**High Street, Great Houghton  
Proposed Residential Development  
Response Report to Combined Stage 1 and 2 Road  
Safety Audit**

February 2026 (Rev 1)

High Street, Great Houghton - Response Report to Combined Stage 1 and 2 Road Safety Audit Project No: 21069					
<b>File reference</b>	O:\High Street, Great Houghton\TEXT\REPORTS\260227 High Street Great Houghton - Designers Response Report (Rev 1).docx				
<b>Issue/revision</b>	<b>Initial Issue</b>	<b>Revision 1</b>	<b>Revision 2</b>	<b>Revision 3</b>	<b>Revision 4</b>
<b>Remarks</b>	Final	RSA Actions			
<b>Date</b>	3 <sup>rd</sup> February 2026	26 <sup>th</sup> February 2026			
<b>Prepared by</b>	R Peach	R Peach			
<b>Signature</b>					
<b>Checked by</b>	S Chapman	S Chapman			
<b>Signature</b>					
<b>Authorised by</b>	M Whittaker	M Whittaker			
<b>Signature</b>

VISIBILITY SPLAY -
PLOTS 43-46 & 1
SCALE - 1:200

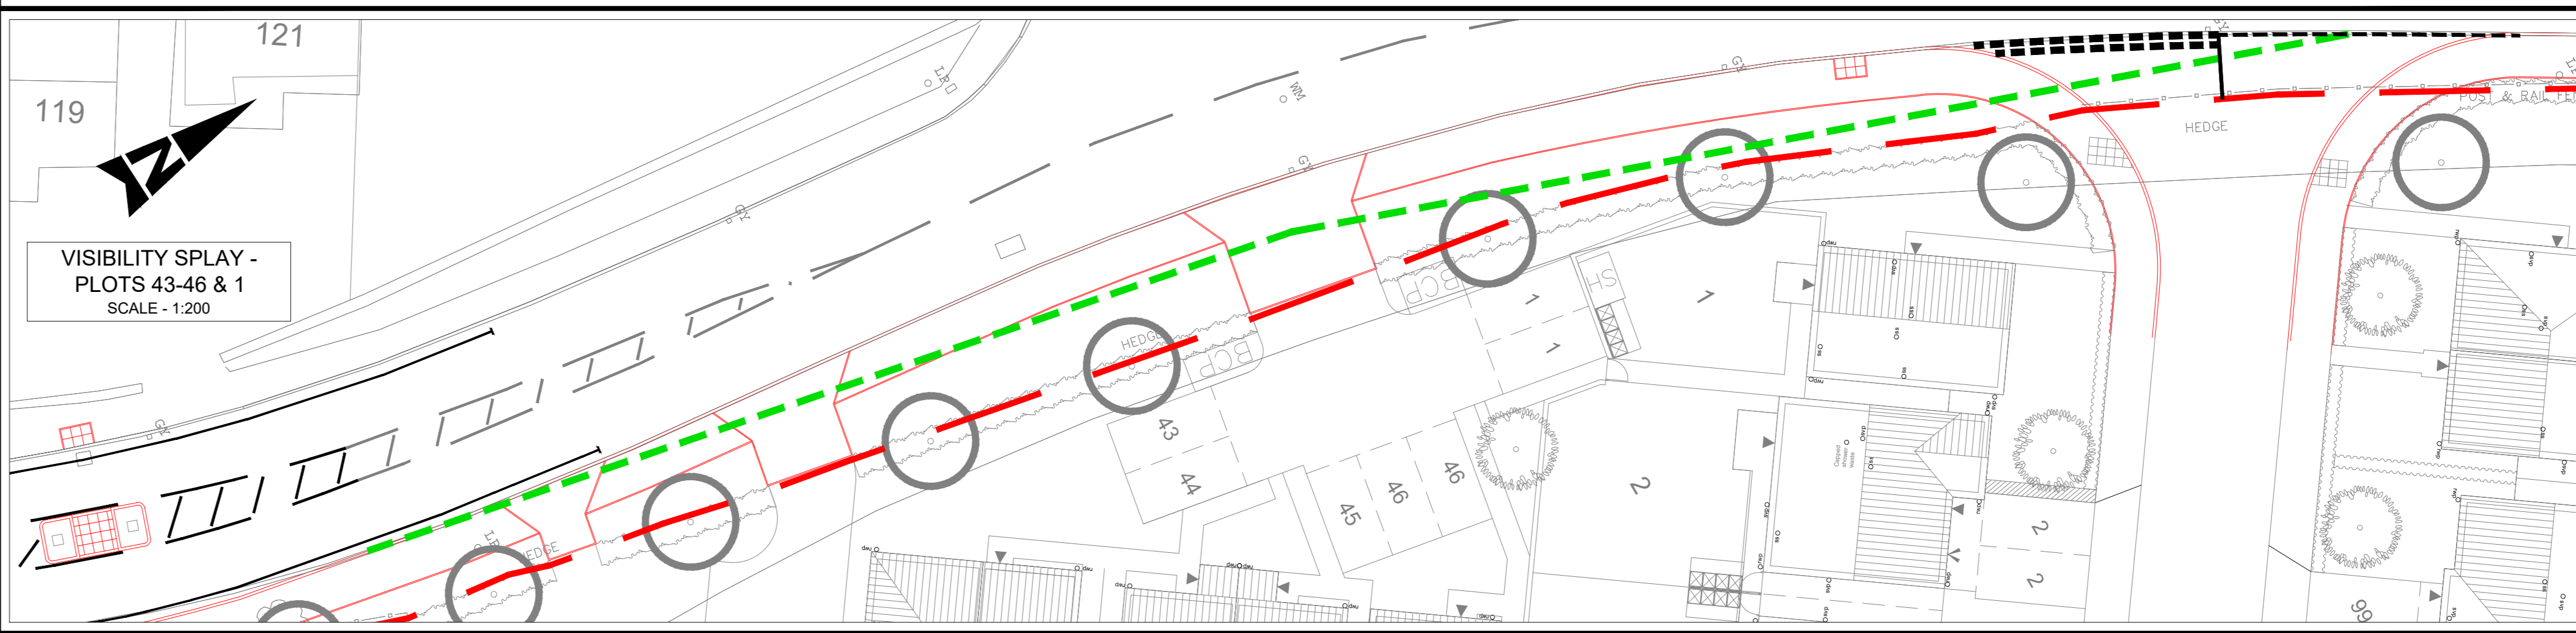
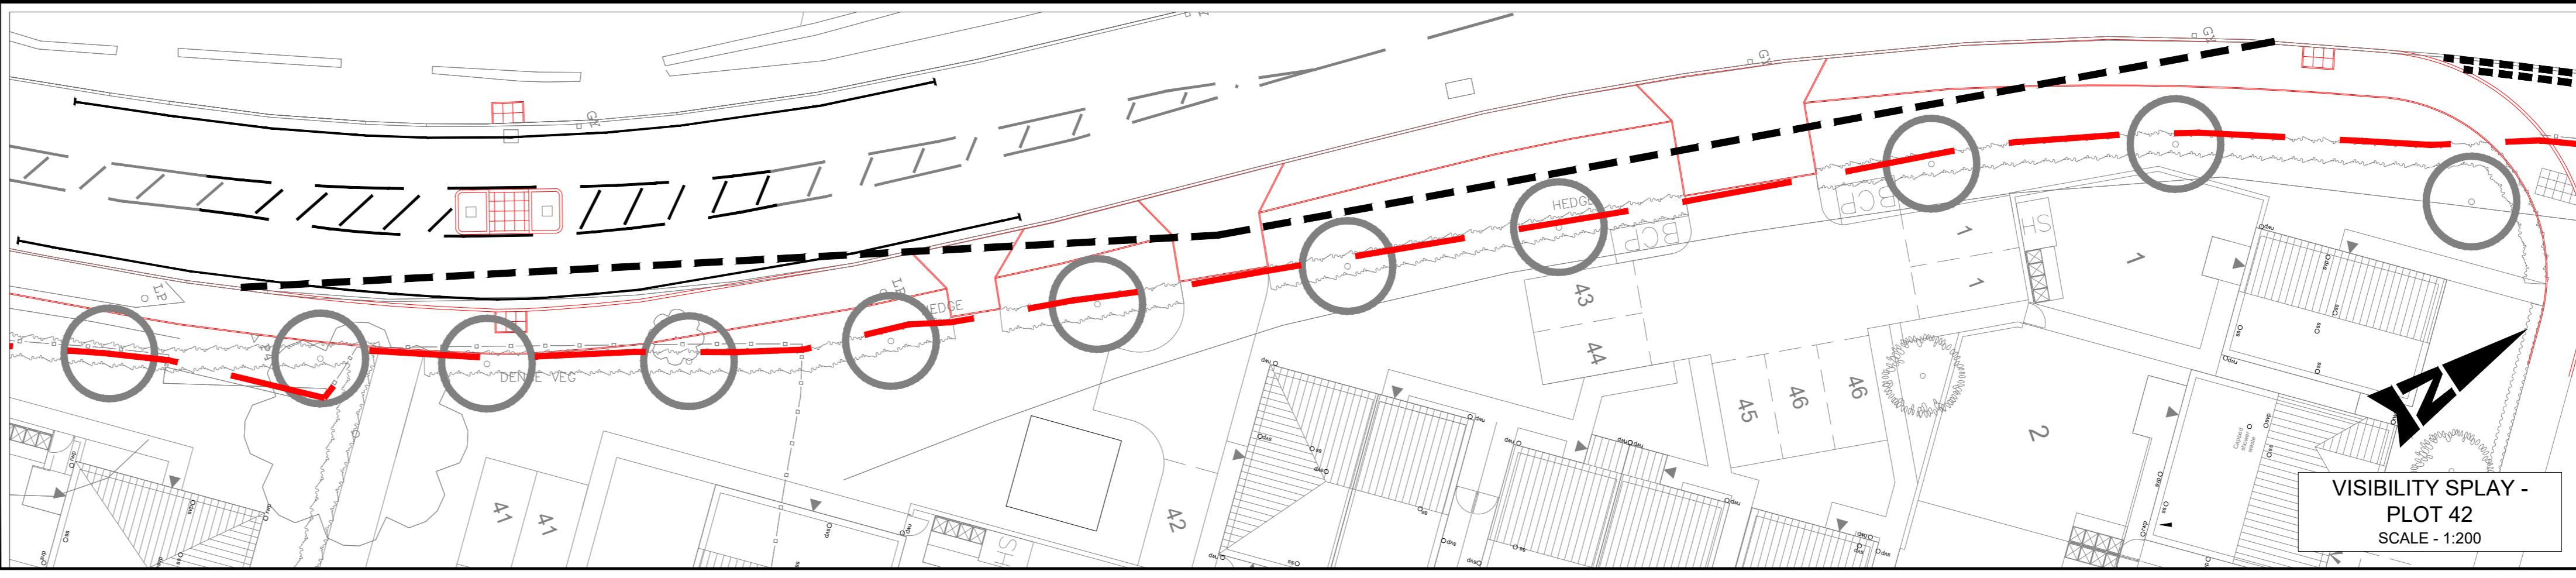
<p><b>3.2.2</b> <b>Location:</b> Development access junction and other proposed vehicle accesses on High Street <b>Summary:</b> Potential for vehicle-to-vehicle collision. <b>Detail:</b> Some of the intended visibility splays include areas of highway verge and are adjacent to property boundaries. If landscaping, hedges, etc. are within the visibility splays, collisions with involving turning traffic are possible, if the correct visibility distances are not achieved in practise.</p>	It is recommended that the visibility splays are kept clear of obstructions e.g. landscaping, property boundary fencing, advertising boards, etc.	<b>Accepted</b> – The proposed visibility splays will be kept clear of obstructions. Visibility splays from all junctions are provided within the adopted highway.	Comments accepted.	No further action required.			
<p><b>3.3.1</b> <b>Location:</b> High Street northbound lane, at the proposed refuge island outside No. 119 <b>Summary:</b> Potential trip hazard. <b>Detail:</b> The inspection cover outside No. 119 High Street is a possible trip hazard for pedestrians using the new refuge island.</p>	It is recommended that either the crossing or the manhole are relocated. If this is not practical, it is recommended that a non-slipcover is installed and that the carriageway is suitably reinstated.	<b>Accepted</b> – The manhole will have a non-slip cover installed and the surrounding carriageway is to be appropriately reinstated - as noted on the Optima Highways Drawing No. <b>21069-GA-03-B</b> in <b>Appendix B</b> .	Comments accepted.	No further action required. Design drawings to reflect the information shown on <b>21069-GA-03-B</b> .
